Comments on the Applicant's Response to Deadline 3 Submissions [Part 9 - Noise] by William David Moore

Introduction

NMP4

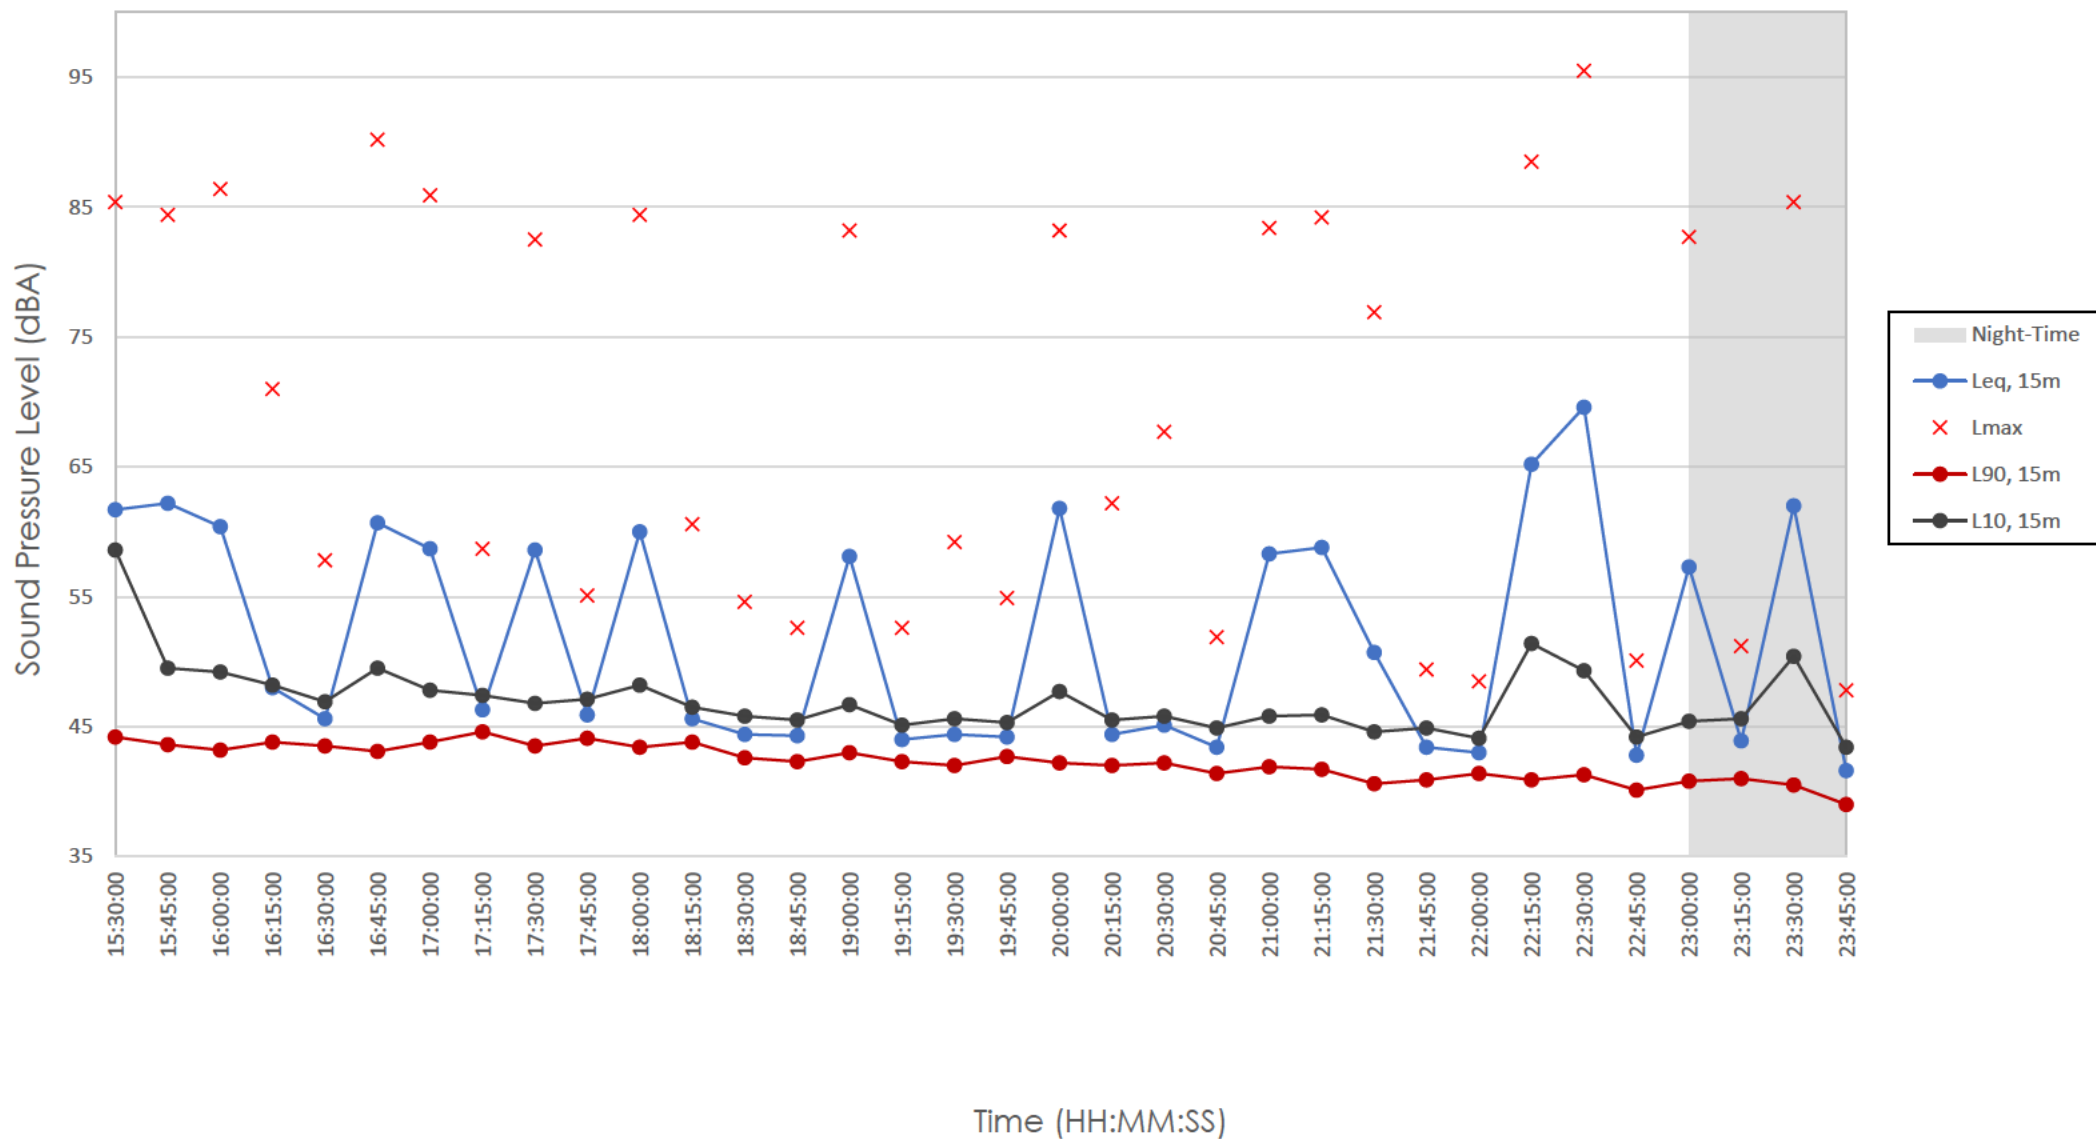
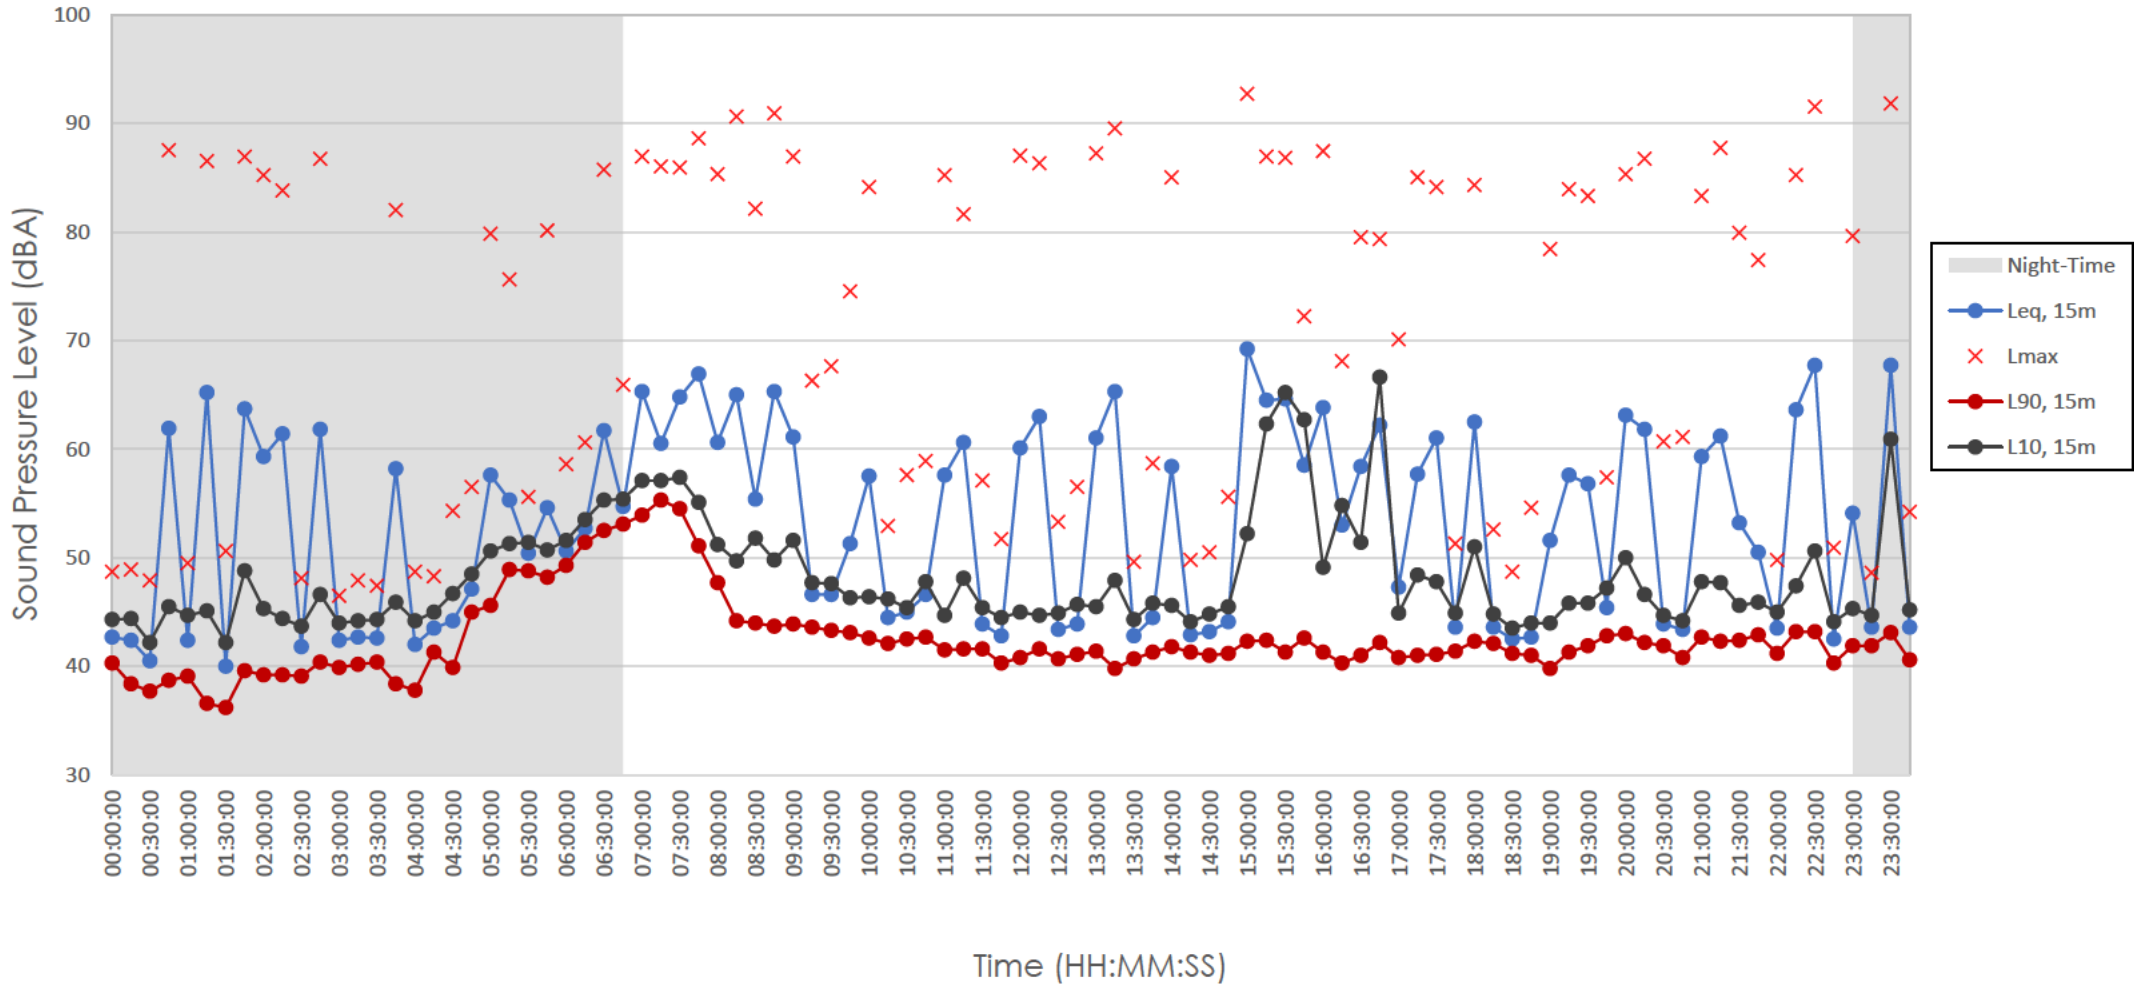
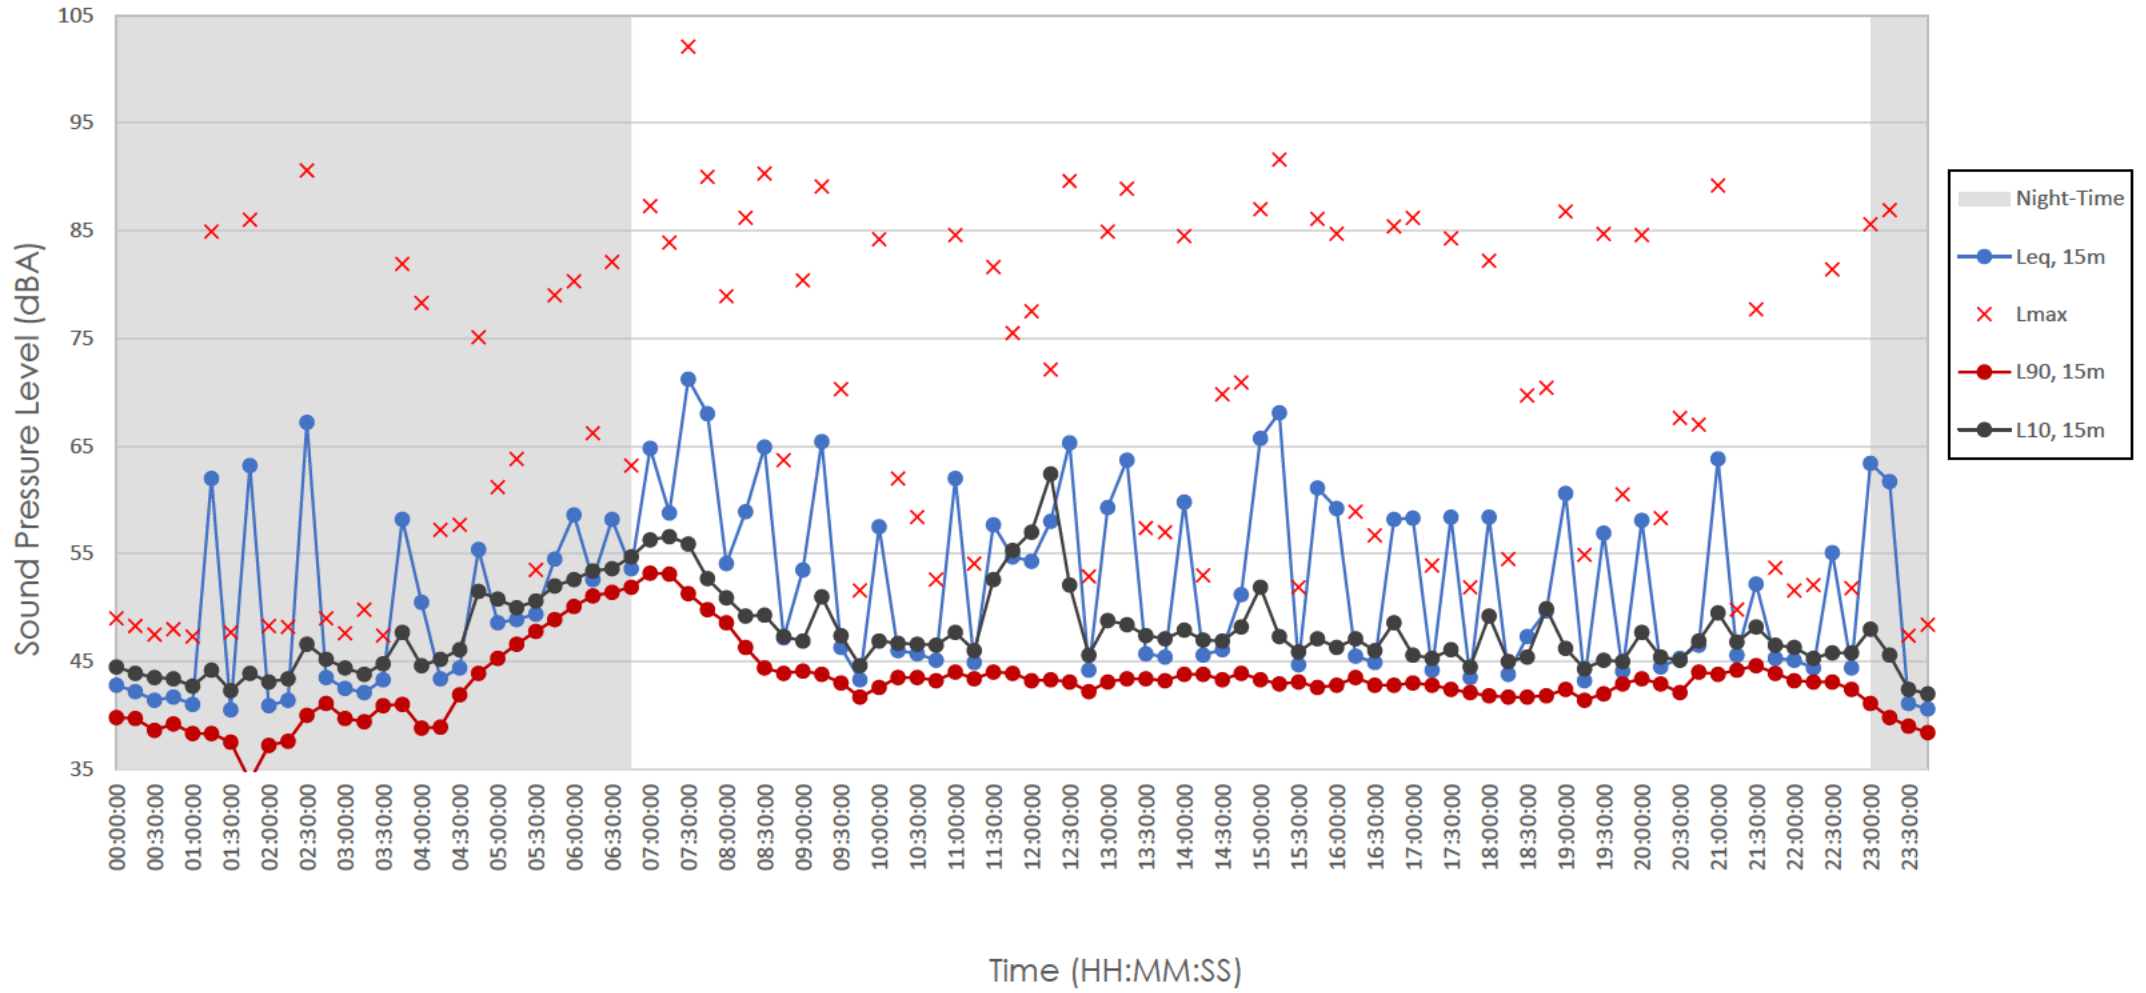
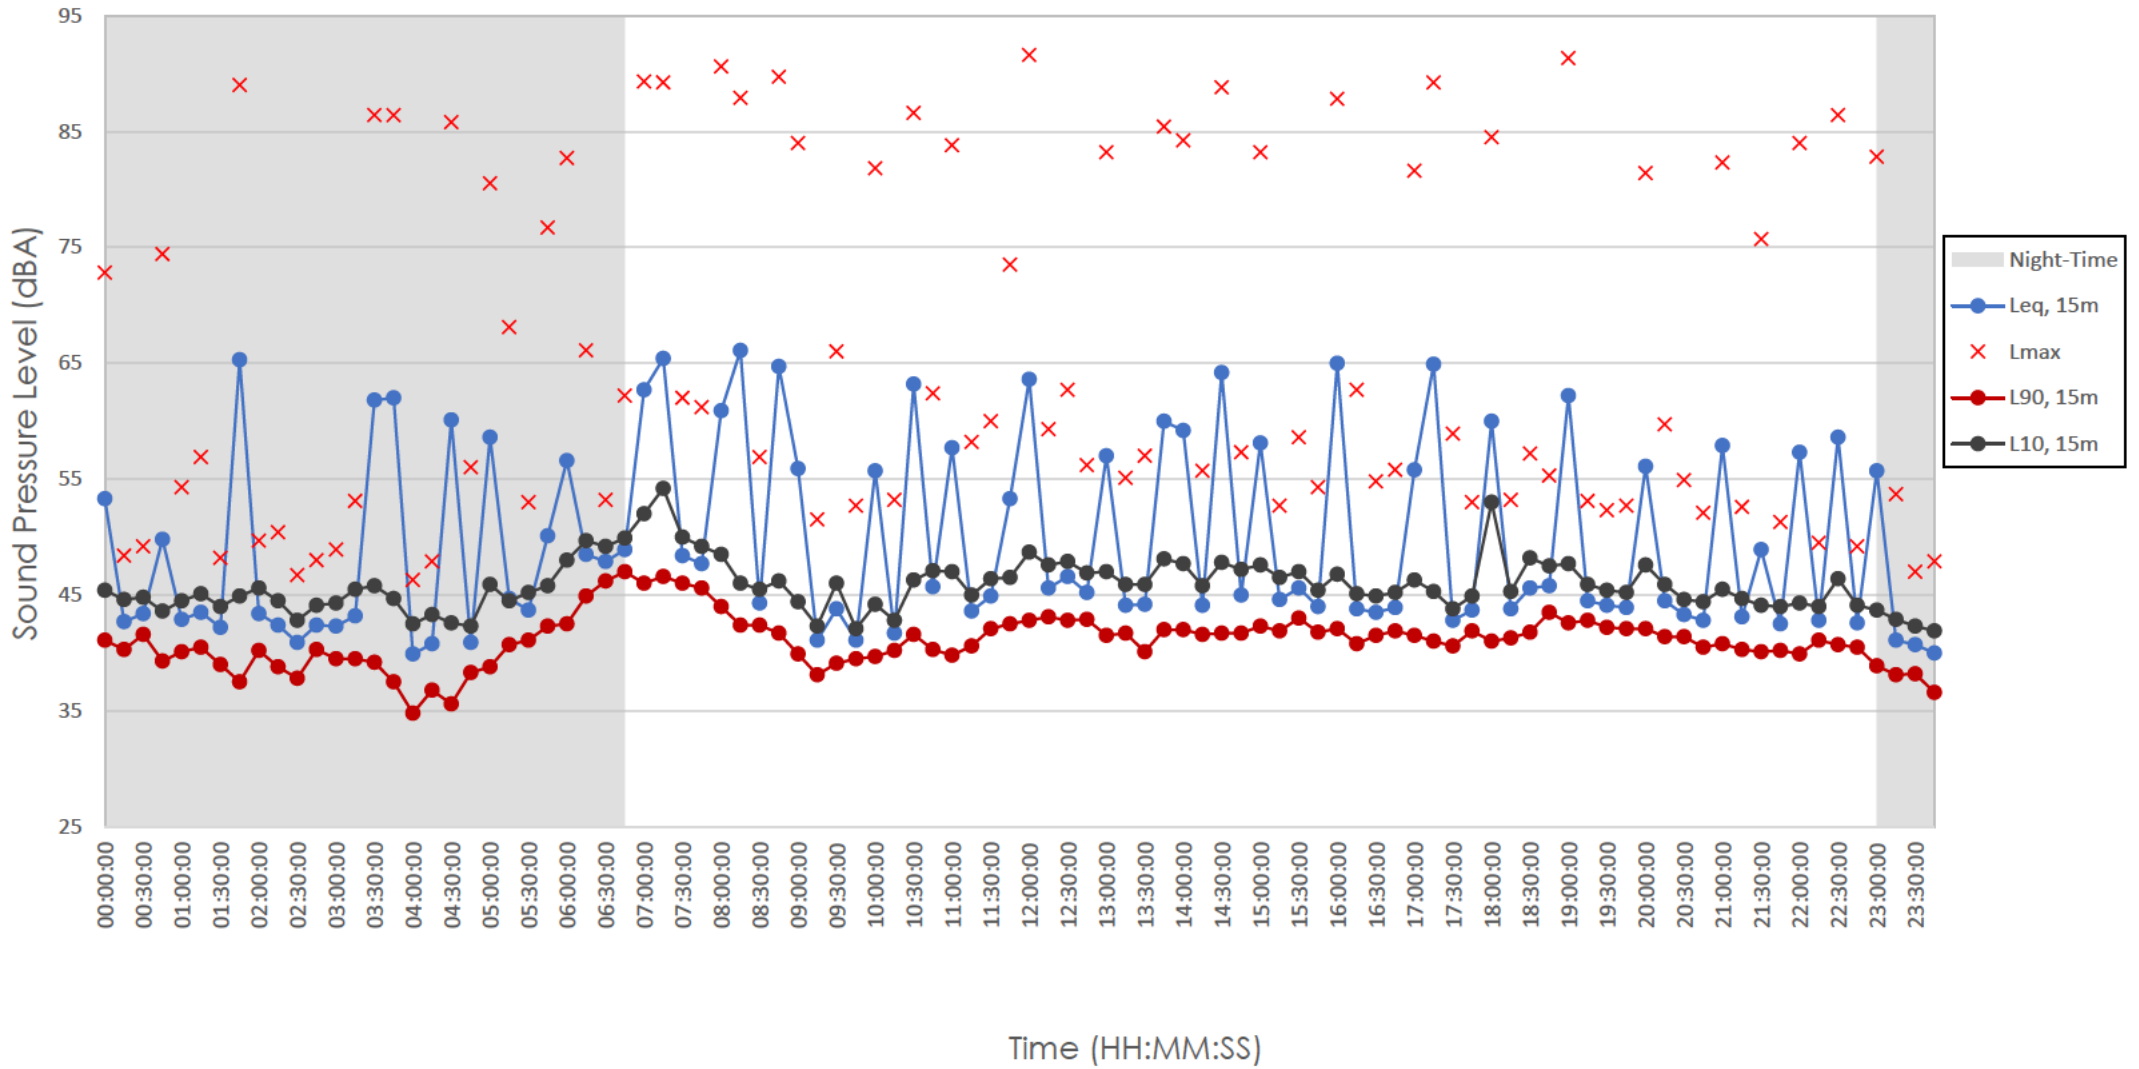
The update note doesn't address all eleven NSRs associated with NMP4. It only addresses the NSRs which it thinks are on Billington Road East.

The update note misstates the locations of NSRs 2, 3 & 4 and they should not have been included in Table 5.

The update note attempts to introduce rail noise contours to claim all the NSRs in Table 5 experience 50 dB of ambient rail noise, but all the NSRs in Table 5 are outside the contours.

The rail noise contours in the applicant's update note show sound levels far higher than those measured by NMP4 & NMP3.

The applicant needs to be returned to the sound levels measured by NMP4 and the applicant needs to apply attenuation corrections to the measured sound of train pass bys to generate ambient sound levels at NSRs 1-8 & 24-26 during weekday daytimes, weekday night-times, weekend daytimes and weekend night-times.

My written representation provided overwhelming evidence that NMP4's measured Saturday night-time noise levels should not have been expunged and that Sunday night-time train pass bys are structurally higher. The evidence showed four consecutive Saturday night-times having a **maximum** of one passenger train which may or may not pass by in the first few minutes of the night.

If the applicant continues to deny reality and continues to refuse to reinstate the Saturday night-time noise levels measured by NMP4 then I will submit yet more evidence. The applicant's purported "understanding" of weekend night-time train pass bys is uninformed.

The applicant is retreating to strategic contours. We have levels measured on the ground at the site: The measurements of NMP3 & NMP4. Both of those NMPs show sound levels far lower than those depicted by the strategic contours which the applicant is attempting to rely on.
